October 31, 2024

Subject: Trails at Aspen Ridge Filing 1
Roadway Repair Recommendations
Colorado Springs, Colorado
Project No. 22.141

During a meeting on October 16, 2024 between representatives of El Paso County Department of Public Works, Colorado Land Acquisition (COLA), and CMT Technical Services - Colorado (CMT), proposed repairs to areas of utility trench settlement within the roadways of the subject development were discussed. CMT was requested to provide a summary of the proposed repairs. The purpose of this letter is to summarize CMT's recommendations.

C:\Users\jmeed\CMT Technical Services\Colorado Forensic - External\Sharepoint - CMT Project Files\22.141.F.Trails at Aspen Ridge Settlement Evaluation\ACAD\22.141.Updated Pavement District ID Map.dwg 9/4/2024 4:28 PM

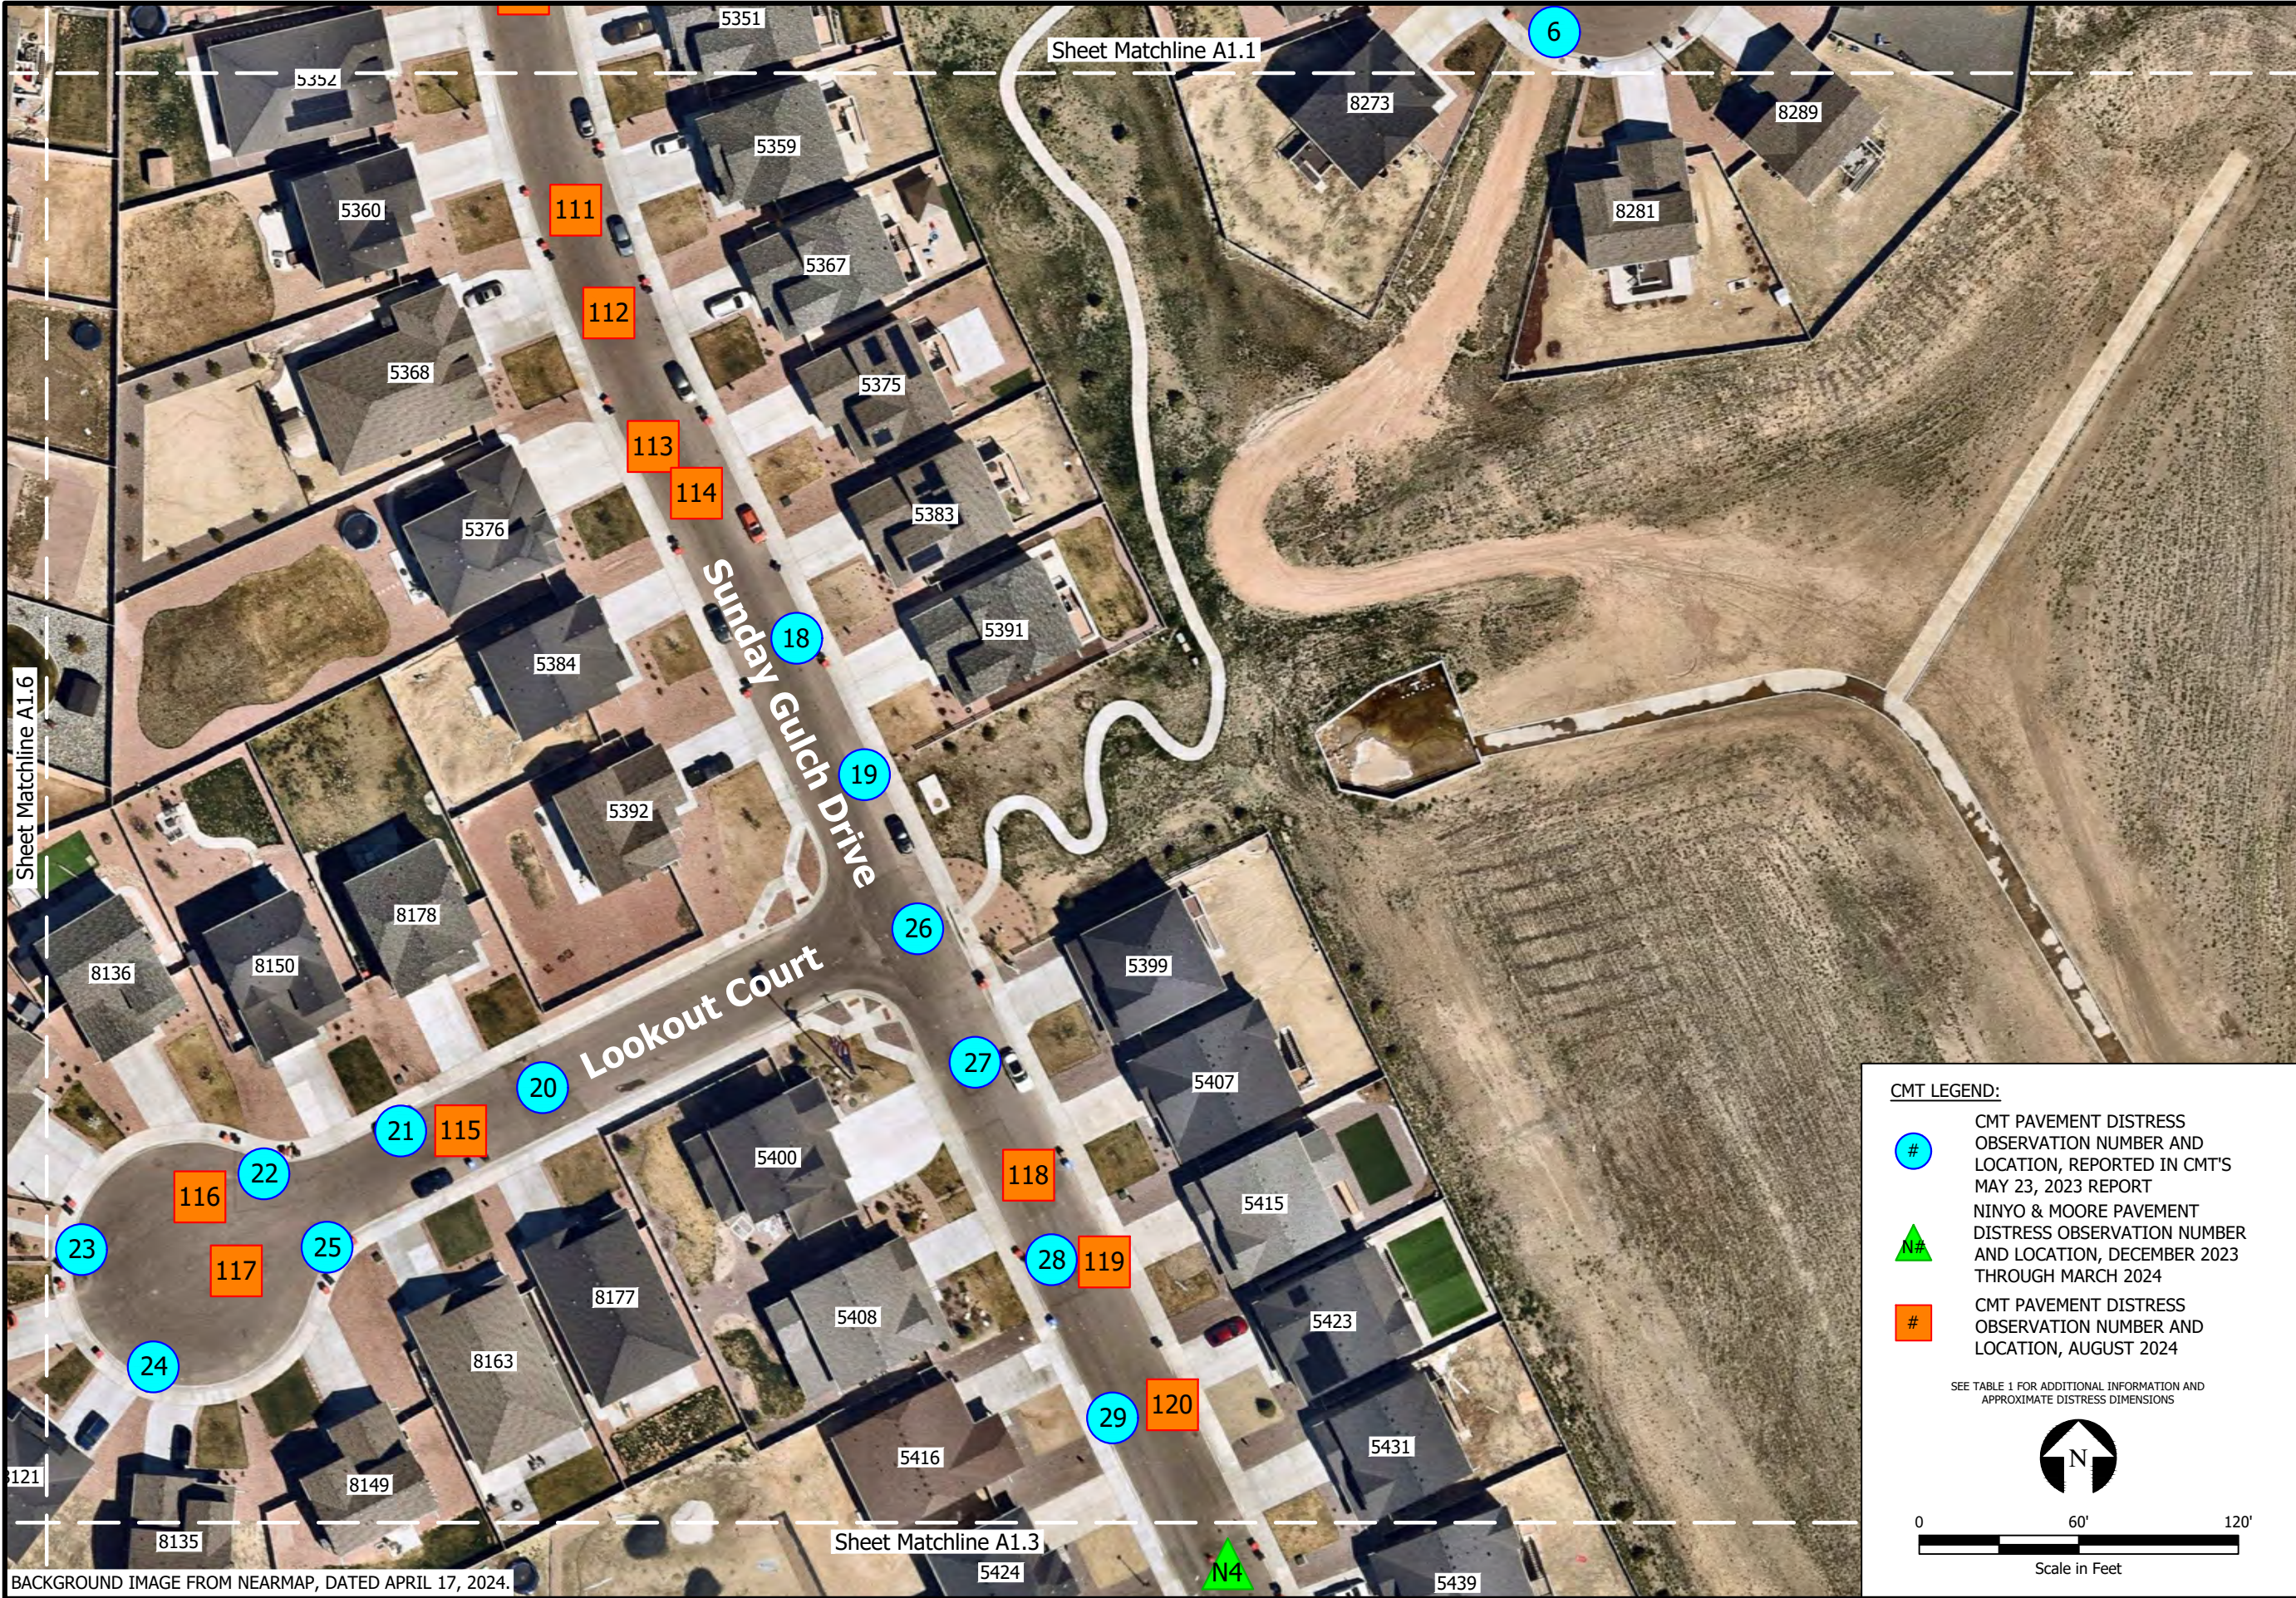
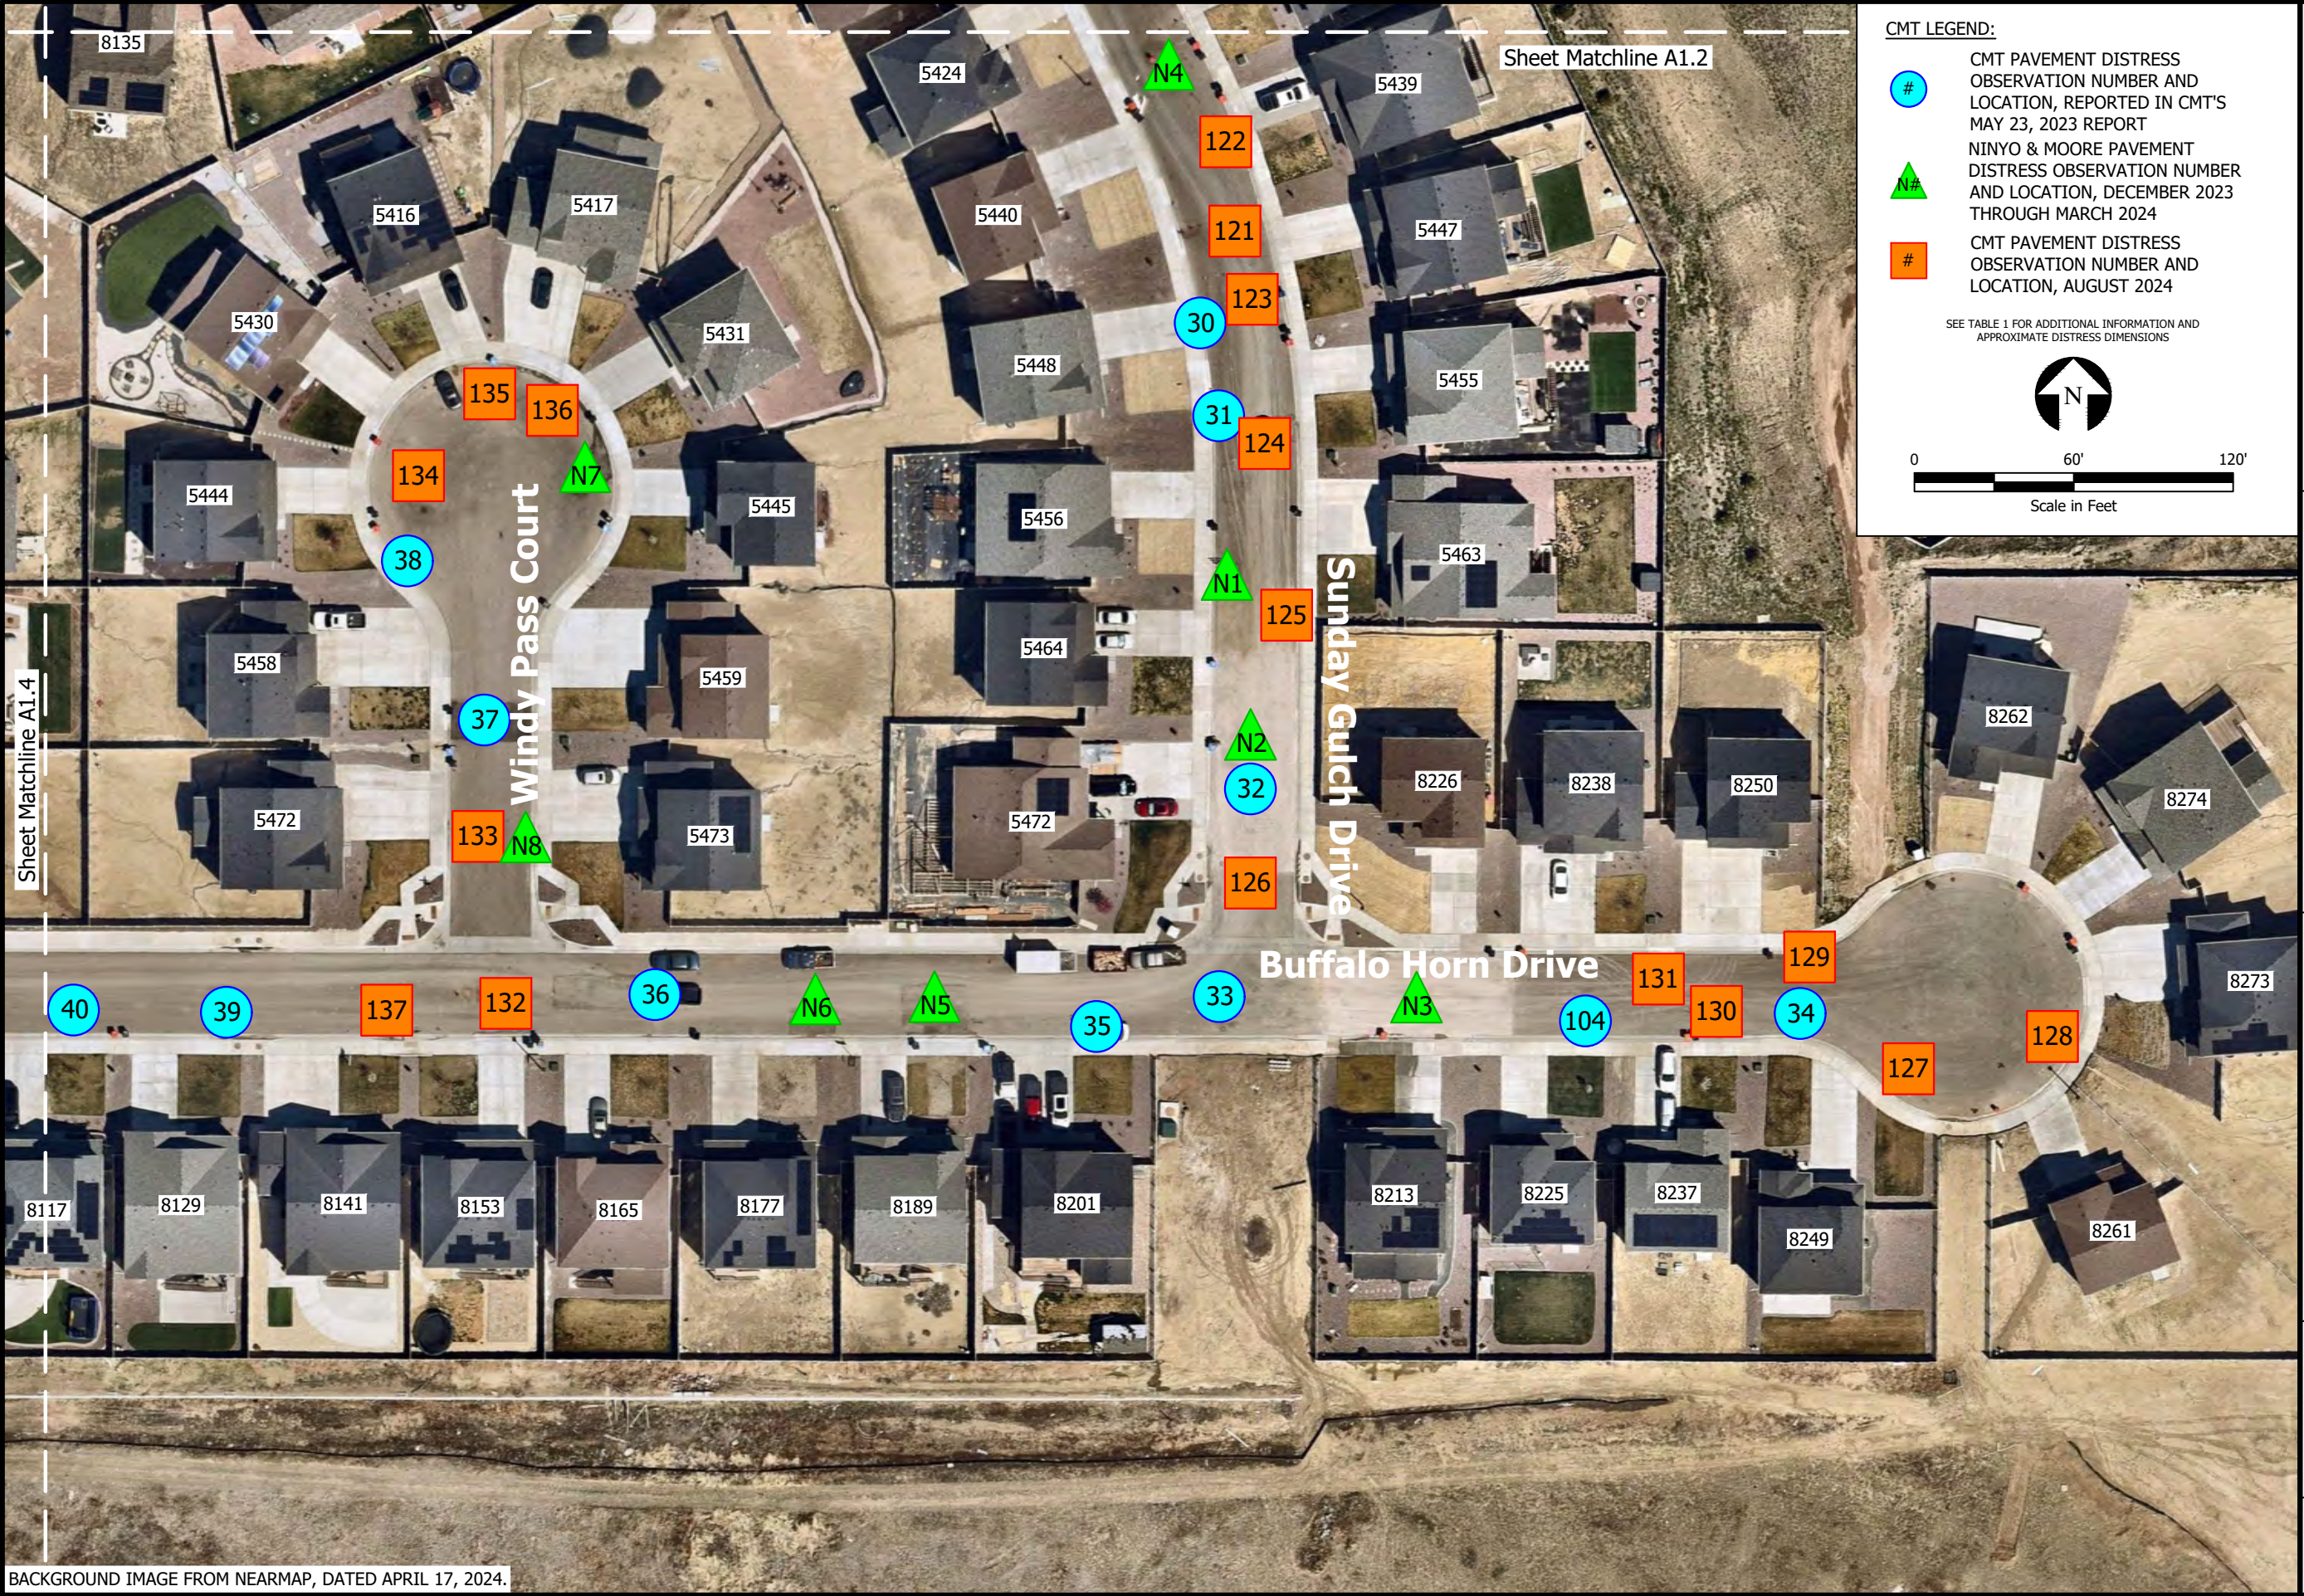
CMT performed observations in November 2022 and August 2024 to observe and document existing distress. CMT's observations are summarized in Tables 1 and 2 and Figures A1.0 through A1.7, appended.

CMT observed that the number of distress locations increased, the severity of previously existing distresses increased, and distress within the mainline trenches had developed during the time period between CMT's November 2022 and August 2024 observations. CMT initially recommended performing isolated excavations where settlement had occurred within the service lateral trenches. The existing extent of distress does not allow for isolated repairs at laterals for a majority of the roadways in Filing 1. There are isolated sections of roads where the distress is still limited to the laterals and isolated repairs at laterals are still recommended. The locations where isolated excavations are recommended include:

- Big Johnson Drive.
- Falling Rock Drive.
- Eastern cul-de-sac of Buffalo Horn Drive.
- Storm Castle Court.
- Wagon Hammer Drive between addresses 5402 and 5426.
